A38 Derby Junctions
TR010022
8.15(b) Statement of Common Ground
with
McDonald's

**Statement of Common Ground
McDonald's**

| Version | Date | Status of Version |
|----------------|--------------|--------------------------|
| Final | 18 June 2020 | Deadline 14 Submission |

RETAINED ACCESS WITH A38 WORKS

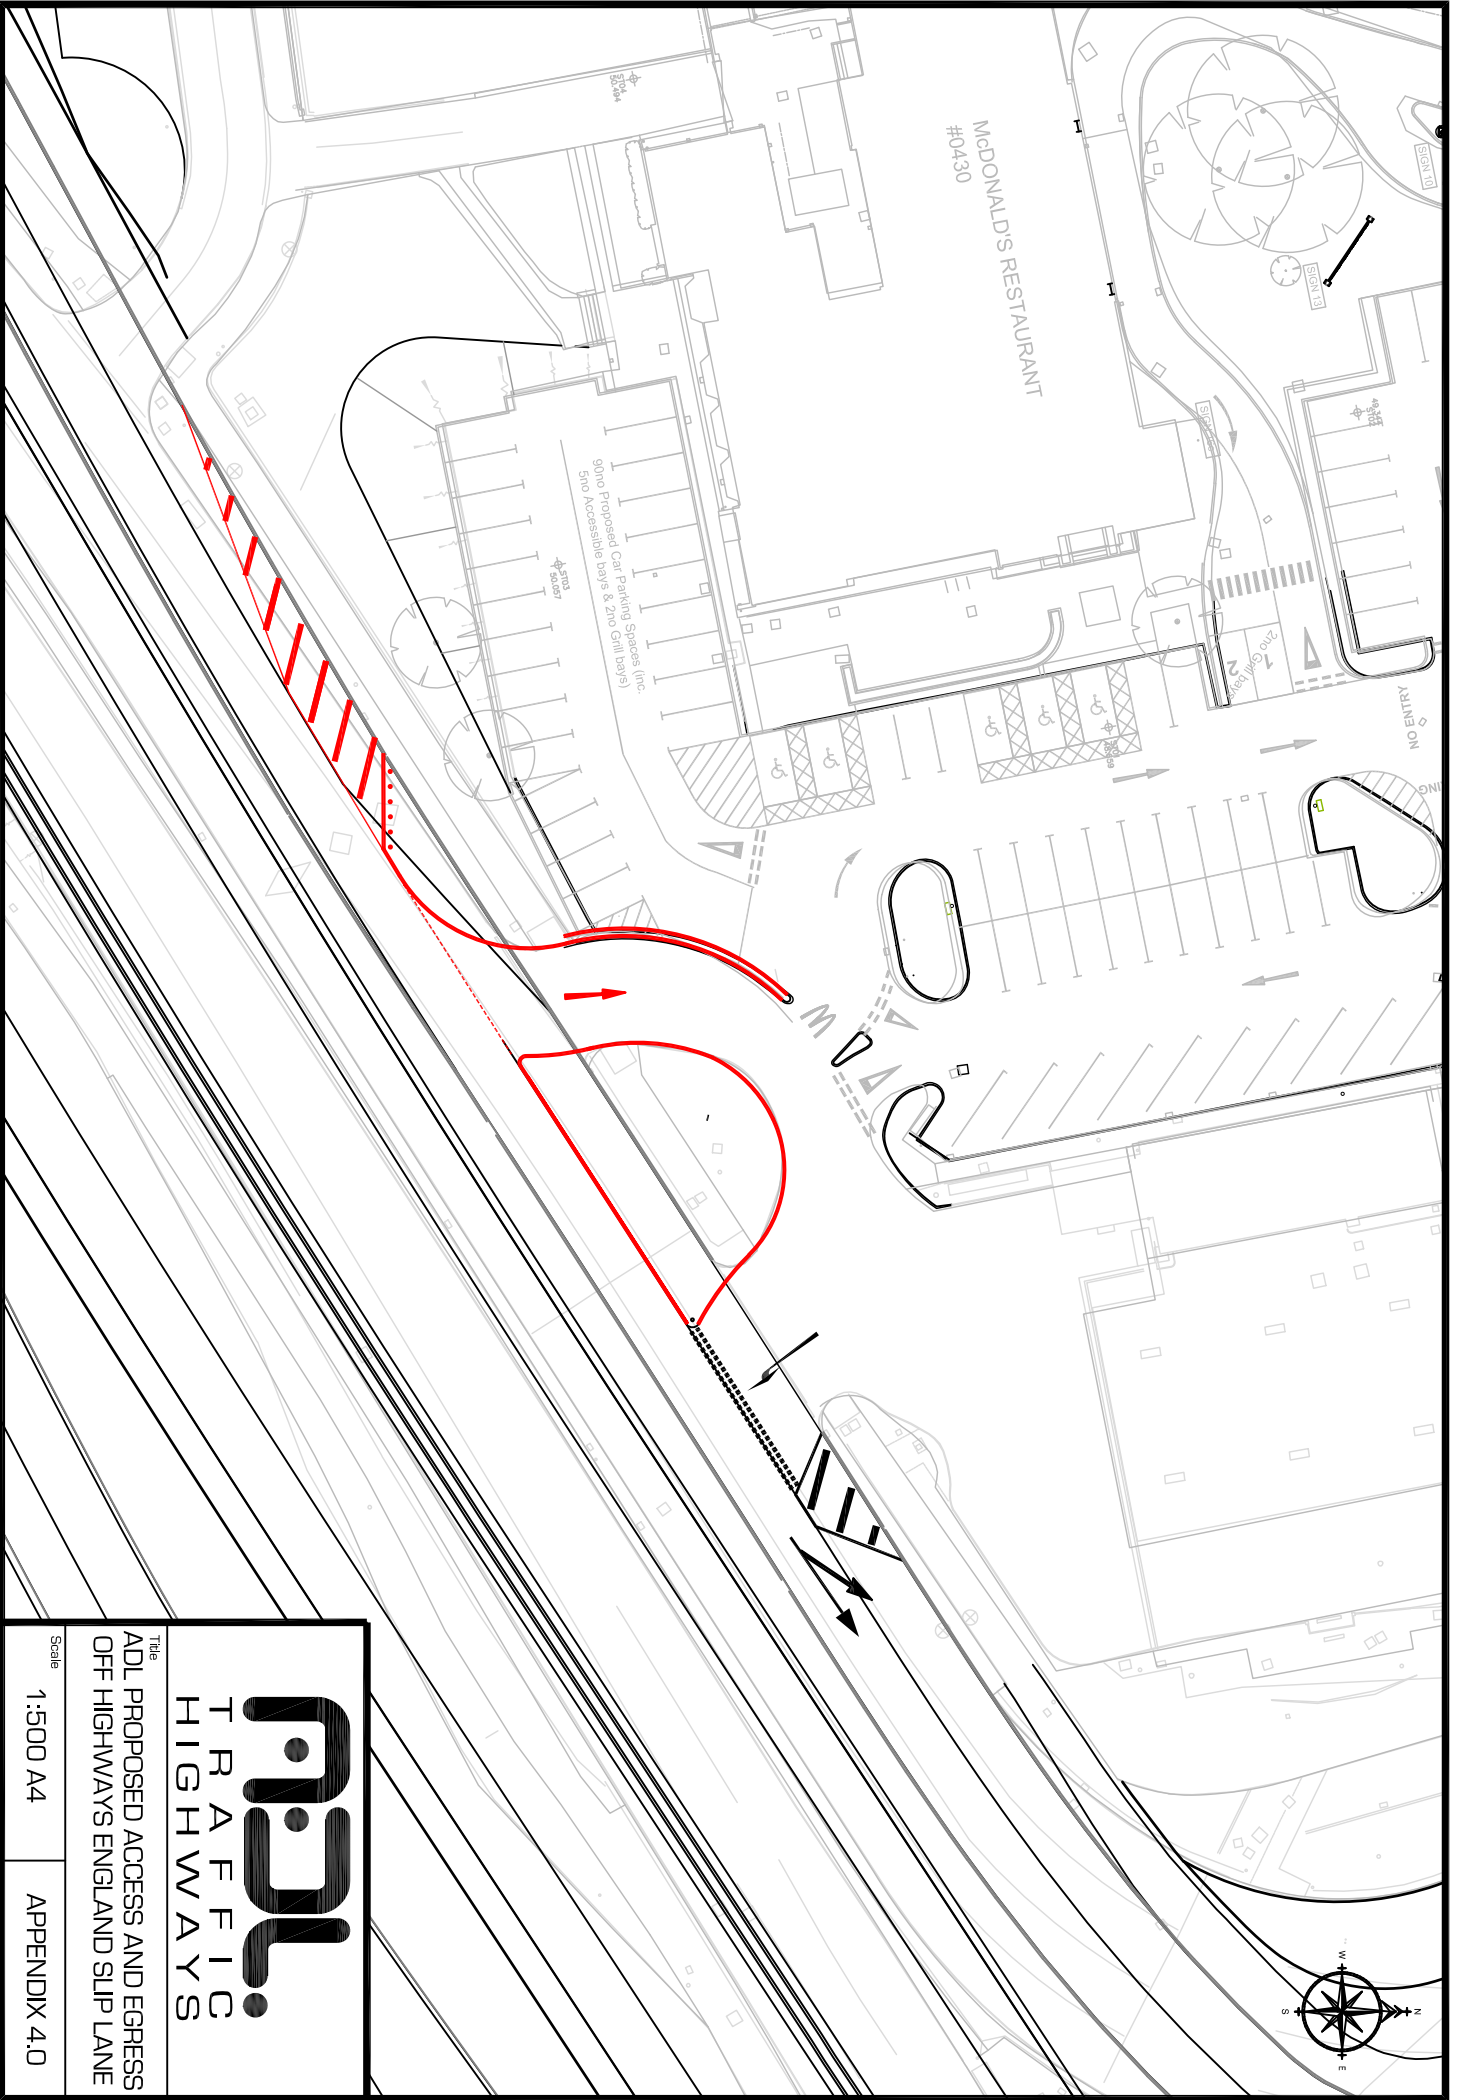
| Issues Reference (see Appendix A) | Document | Paragraph Ref | Sub-section | Comment | Highways England Response | Status |
|---|----------------------------------|---------------|-------------|---|--|--------|
| Issues ref: I.1, access and economic impact | Written Representation Comments* | Point 1 | a) | The Works involve closing the entrance to the Property from the A38. This would cause increased queuing at the Ashbourne Road entrance and exit to the Property, posing a health and safety risk to road users, as well as negatively impacting McDonald's business, brand, sales, operations and the amenity of the local area for residents (in each case during and after the works). Additionally, the increased capacity at the Ashbourne Road junction will go beyond its capability. | <p>Exiting the site onto the A38 will continue to be an option after implementation of the scheme. Entry to the site from the A52 will be via a new signal-controlled junction so will not cause queuing within the site.</p> <p>At the meeting on the 16th of June Derby City Council noted the proposed design is safe and acceptable in principle.</p> | Agreed |
